Addendum 1: Allegro Acoustics Response to TII Comments from Metrolink Hearing - Module 1

Prepared By: Dirun Ergin & Stephen Kearney

Date: 20th of March 2024

Drawing Title
Figure 14.6 Groundborne Noise from Operation
Sheet 1 of 7

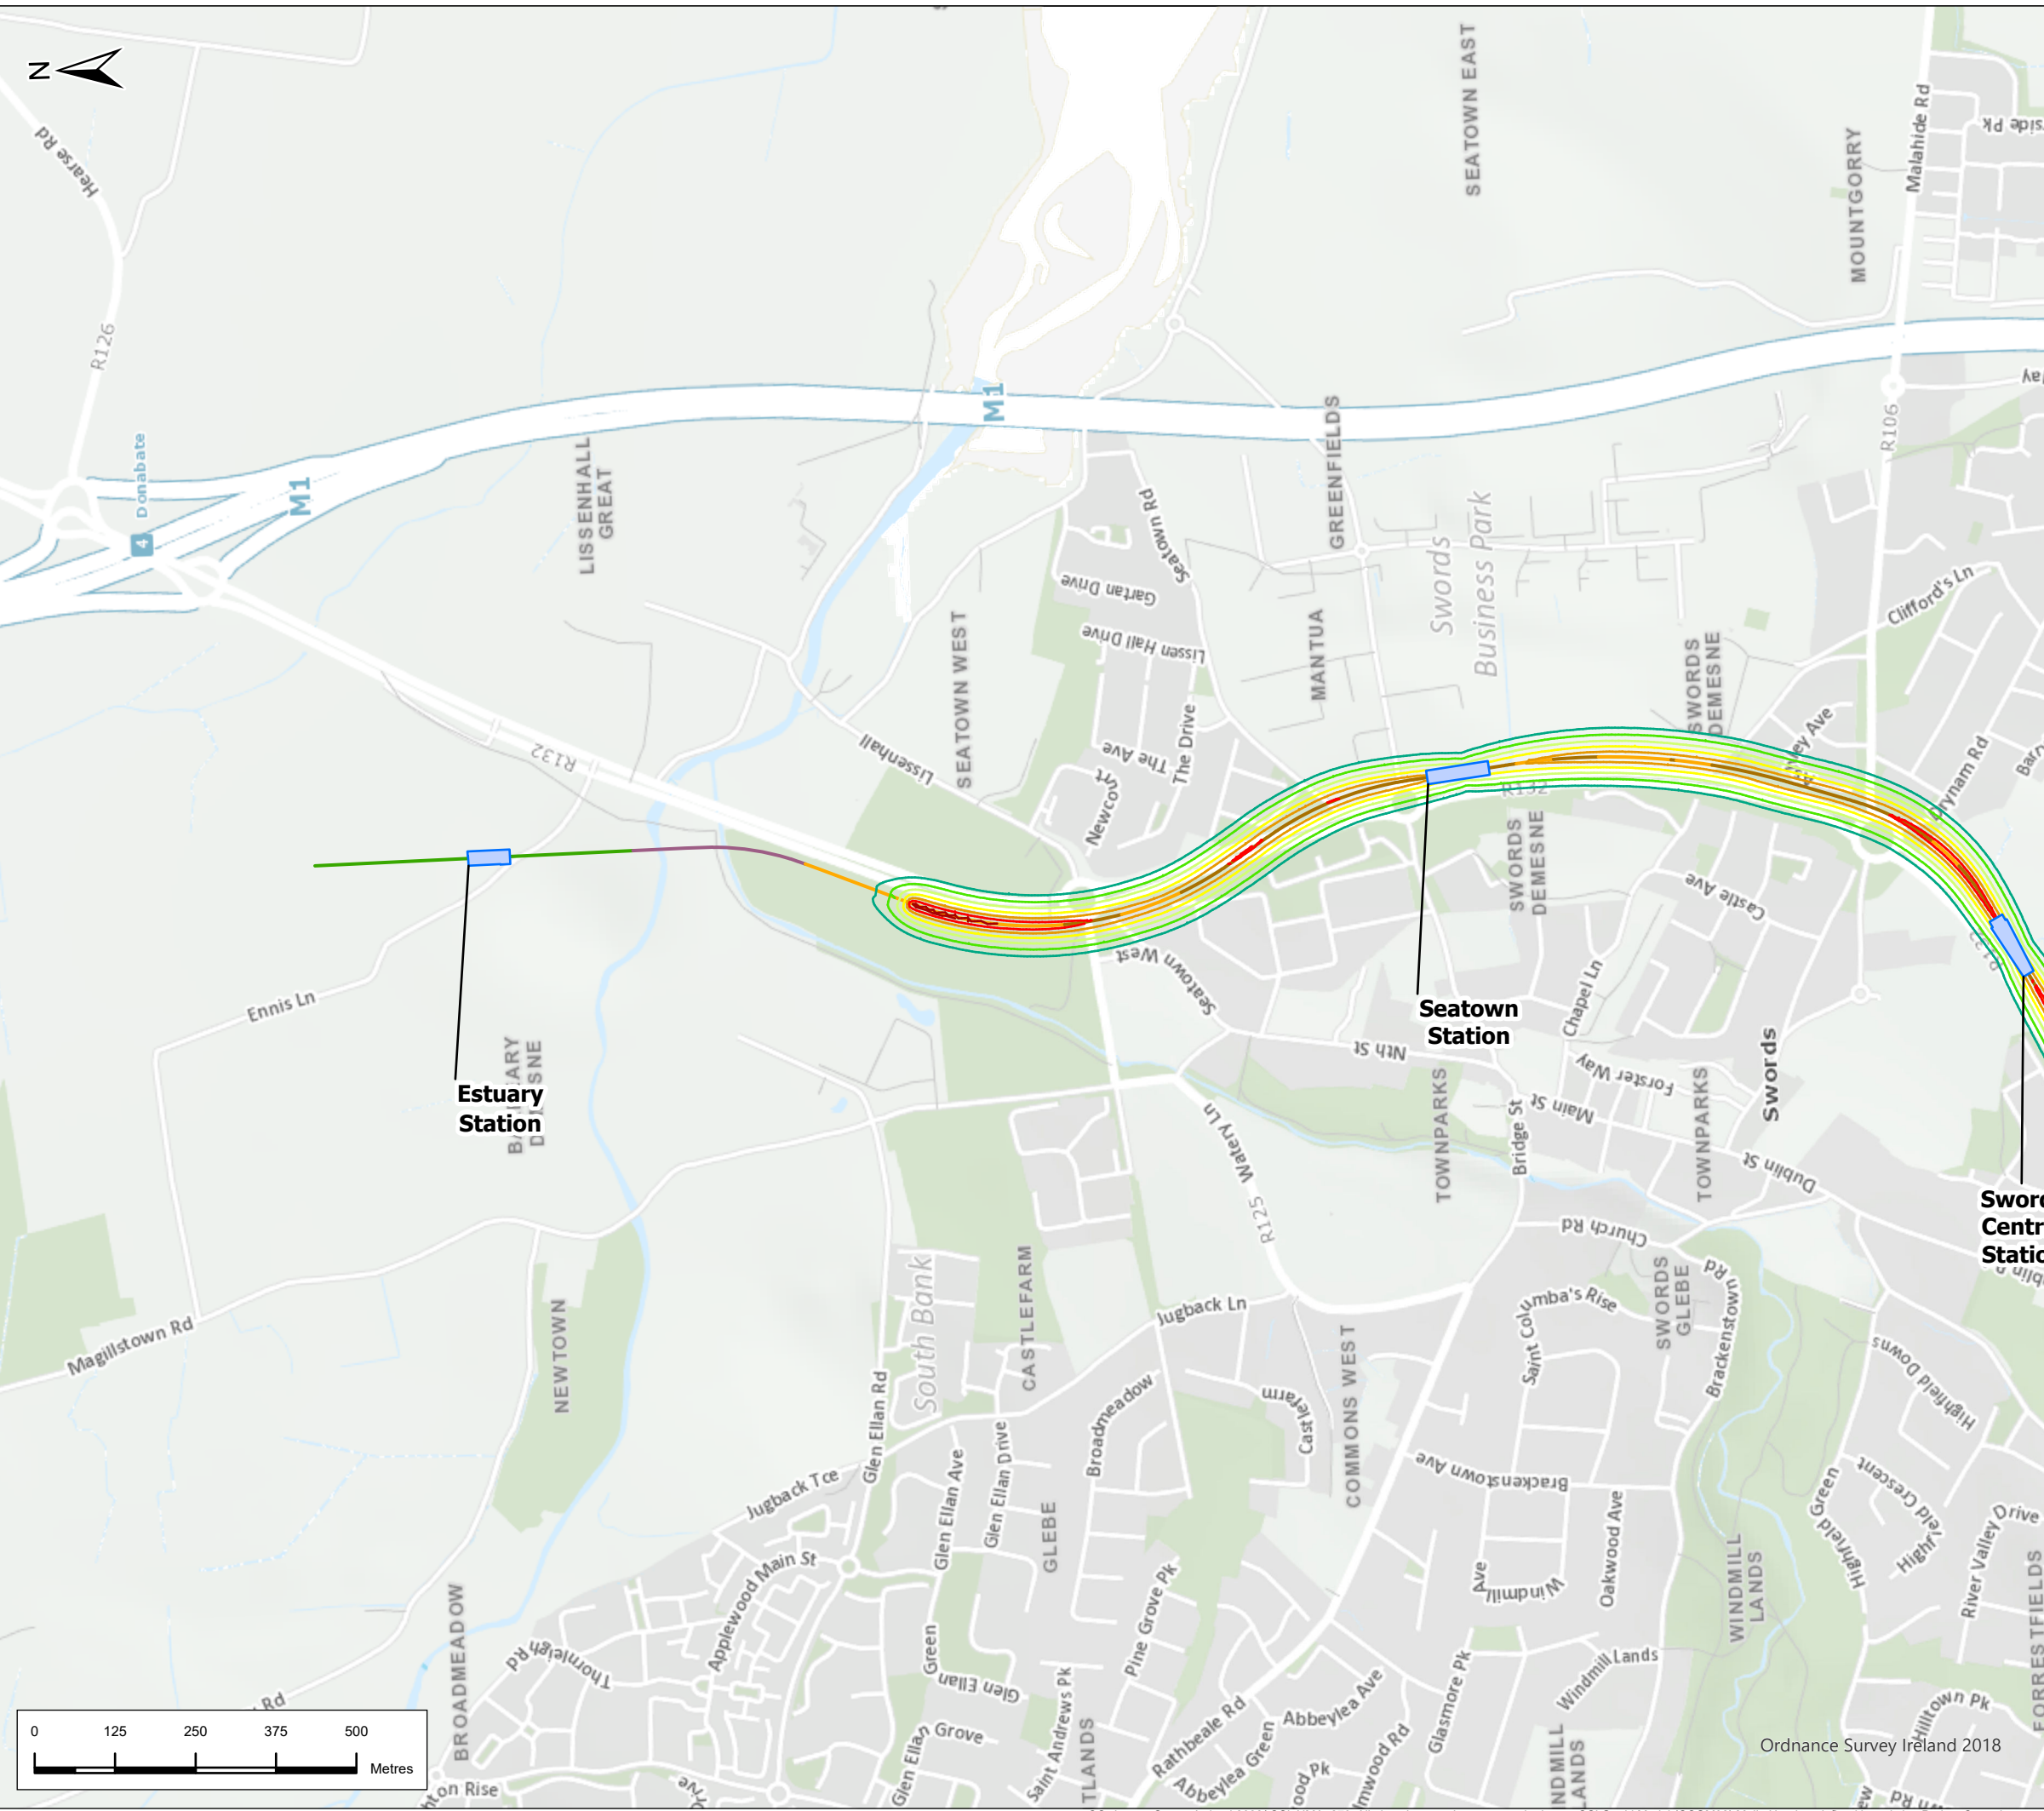
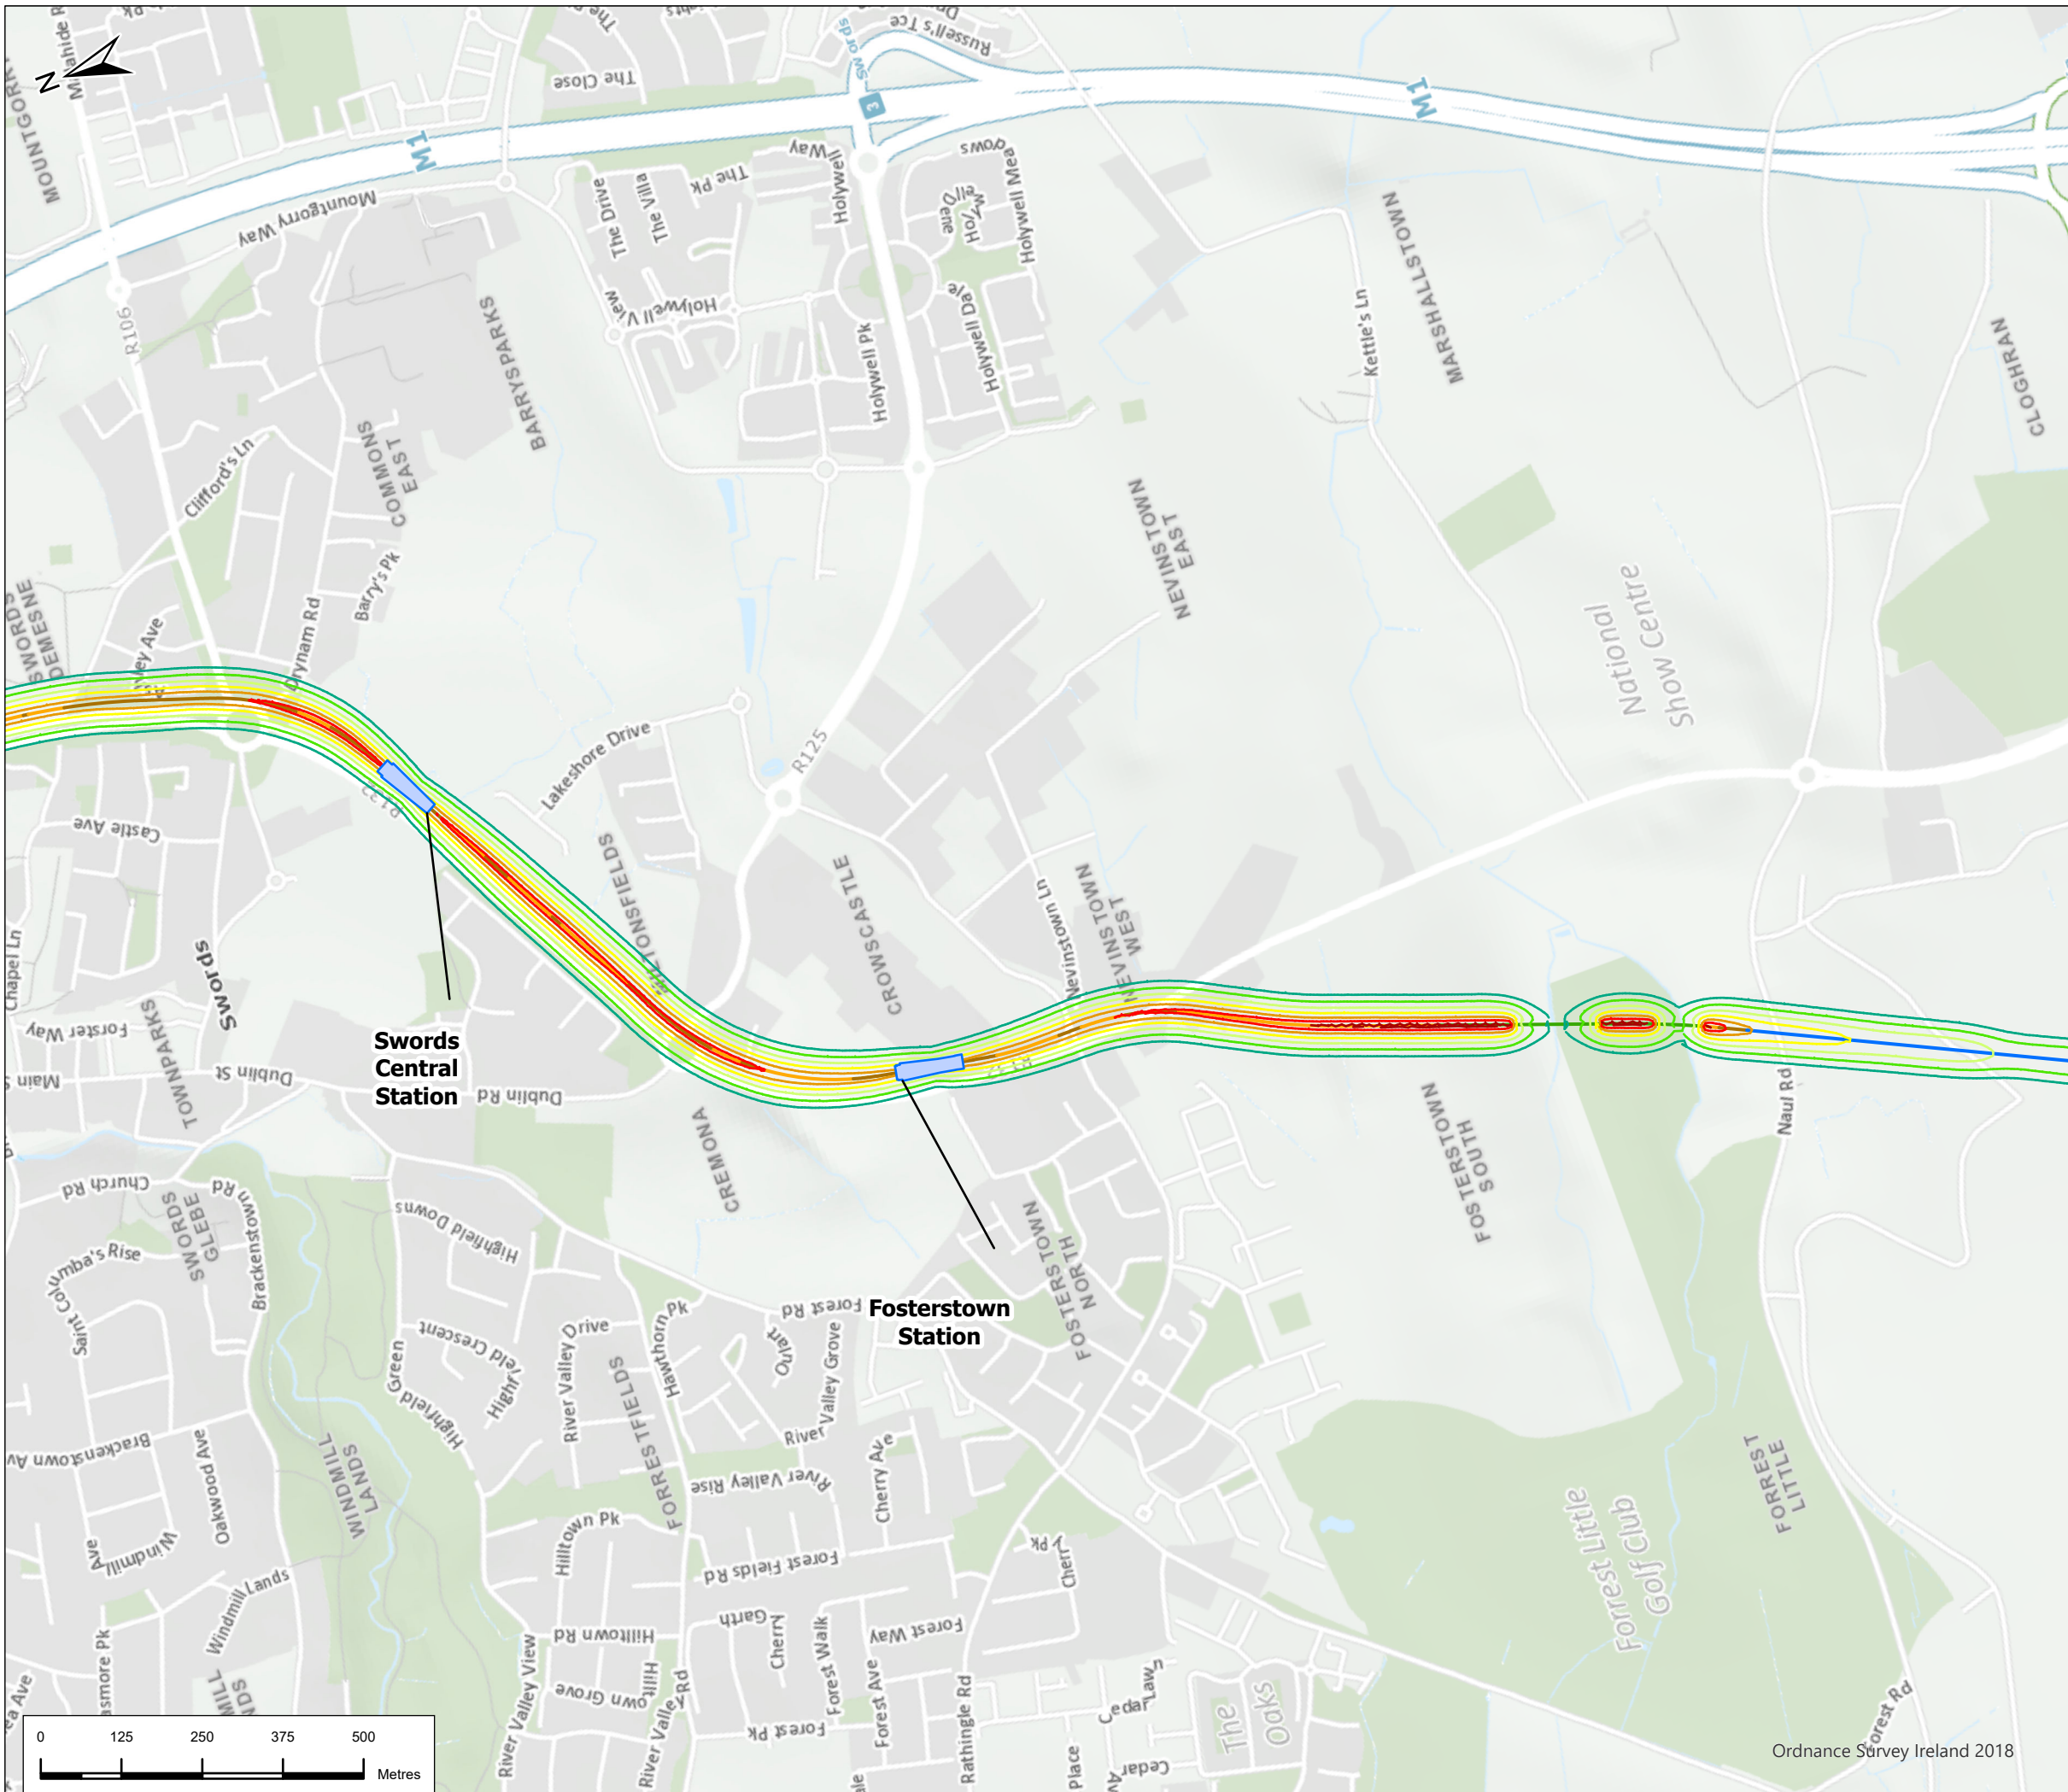
Allegro Acoustics' concern with the proposed 40dB $L_{Amax,s}$ criteria for ground borne noise is primarily for the operational phase of this project. The Cadenza building has been designed and built to provide a high level of acoustic comfort to the users of this space.

The aforementioned 2019 *Guide to Specification Best Practice for Offices* notes in Section 11.4.2 that the proposed 40dB $L_{Amax,s}$ criteria may still be perceptible and that "each case must be examined carefully accounting for the occupants' uses and expectations". Allegro Acoustics does not feel that the proposed 40dB $L_{Amax,s}$ criteria appropriately allows for acoustic comfort in line with the expectation of the users of the Cadenza building.

Section 11.4.2 of this document refers to the *ANC Guidelines, 'Measurement and Assessment of Ground-borne Noise & Vibration'*. The ANC Guidelines note in Table 18.10 that the proposed 40dB $L_{Amax,s}$ criteria is the **Significant Impact Threshold** for ground borne noise in an office setting.

Allegro Acoustics notes that the users of the Cadenza building expect a high level of acoustic comfort to use the building appropriately. As such the ground borne noise criteria should be significantly below the 40dB $L_{Amax,s}$ **Significant Impact Threshold**.

On this basis Allegro Acoustics asks that the TII adopt an operational phase ground borne noise level criteria of ≤ 35 dB $L_{Amax,s}$ criteria to the Cadenza Building to ensure that the likelihood that users of this space are negatively affected by the operation of the MetroLink is kept to a minimum and so that the acoustic comfort level that the building was designed to provide is maintained.

Allegro Acoustics ask TII to confirm that they will carry out operational phase noise impact calculations that account for the realignment of the tunnel height and position at the Cadenza building.
